**Consultation Response from KC,  
Highways Development Management**

**2025/93153 George Hotel, St George's Square, Huddersfield, HD1 1JA**

**Discharge of details reserved by condition 14 (construction traffic access) on previous permission 2025/91147 for refurbishment and redevelopment of the George Hotel (including partial demolition, partial reconstruction and extension) to provide 108-bedroom hotel with bar, restaurant, gym, conference facilities and ancillary facilities (Listed Building and within a Conservation Area)**

**Date Responded: 27/11/2025**

2.1 PRIMARY ROUTES TO SITE

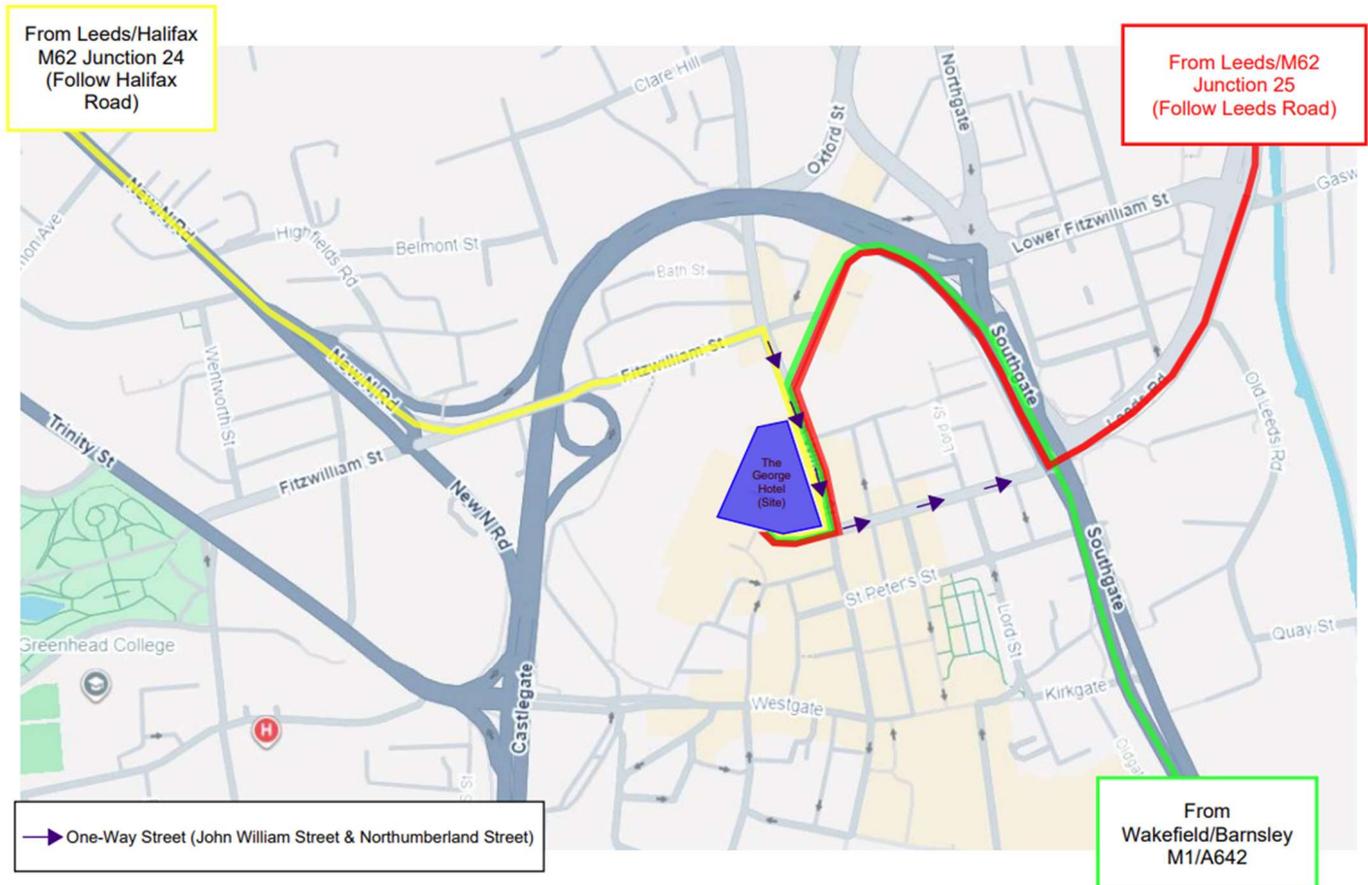
The access routes to the site is indicated on the map contained in section 2.1 - Primary Routes to the Site and this is acceptable.

2.2 JOHN WILLIAM STREET TRAFFIC MANAGEMENT

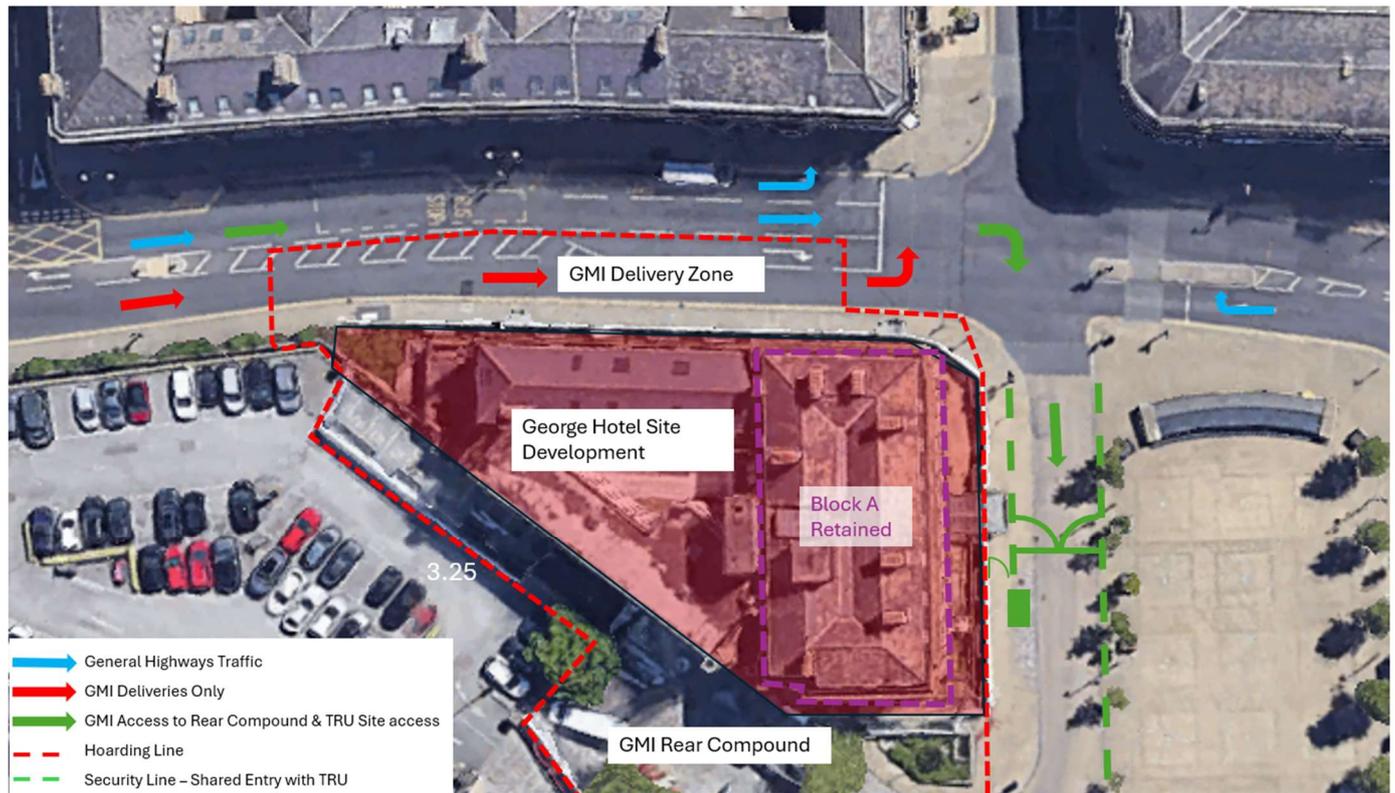
The access points into the site and the loading area are shown on the photograph included in section 2.2 - John William Street Traffic Management and are acceptable. It should be noted that the correct licencing and agreements with Kirklees as the Local Highway Authority will need to be arranged prior to the temporary closure of John William Street.

2.7 MAINTAINING & PROTECTING THE HIGHWAY

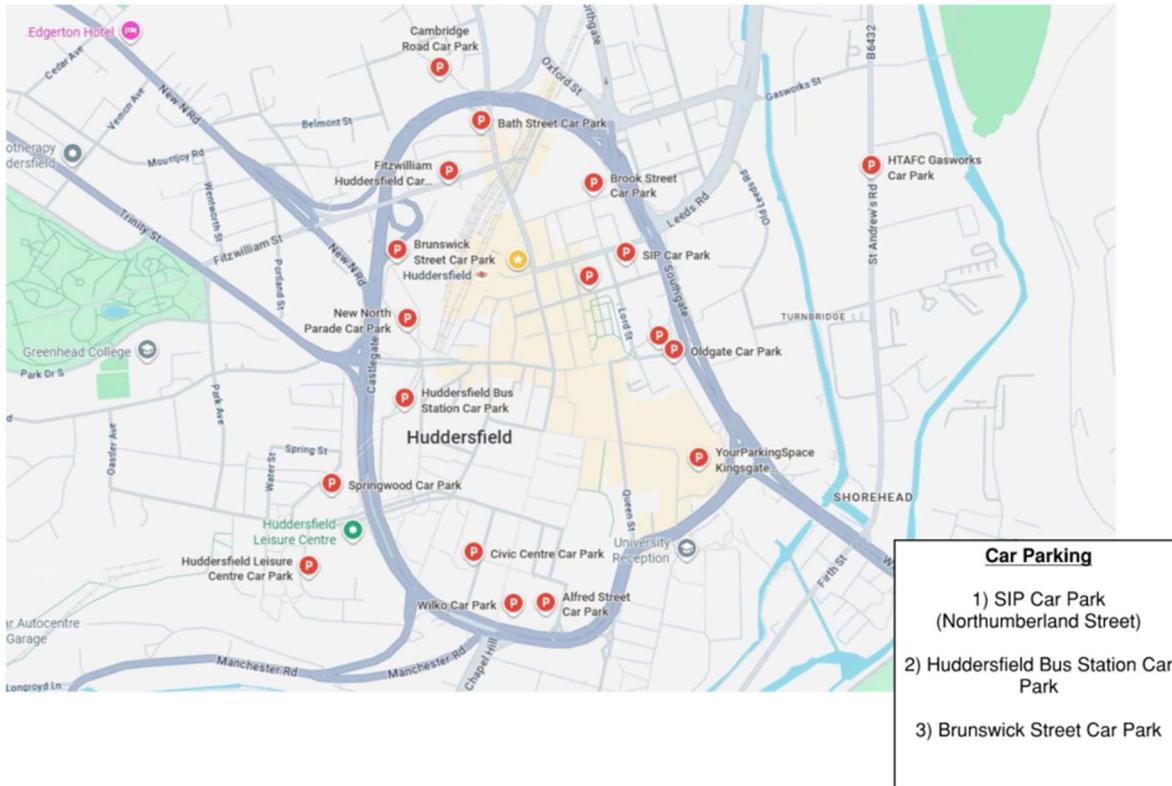
Details of the use and retention of wheel washing facilities and the use of heavy duty track matting to protect the surface of the highway is included in section 2.7 – Maintaining and Protecting the Highway and this is acceptable.
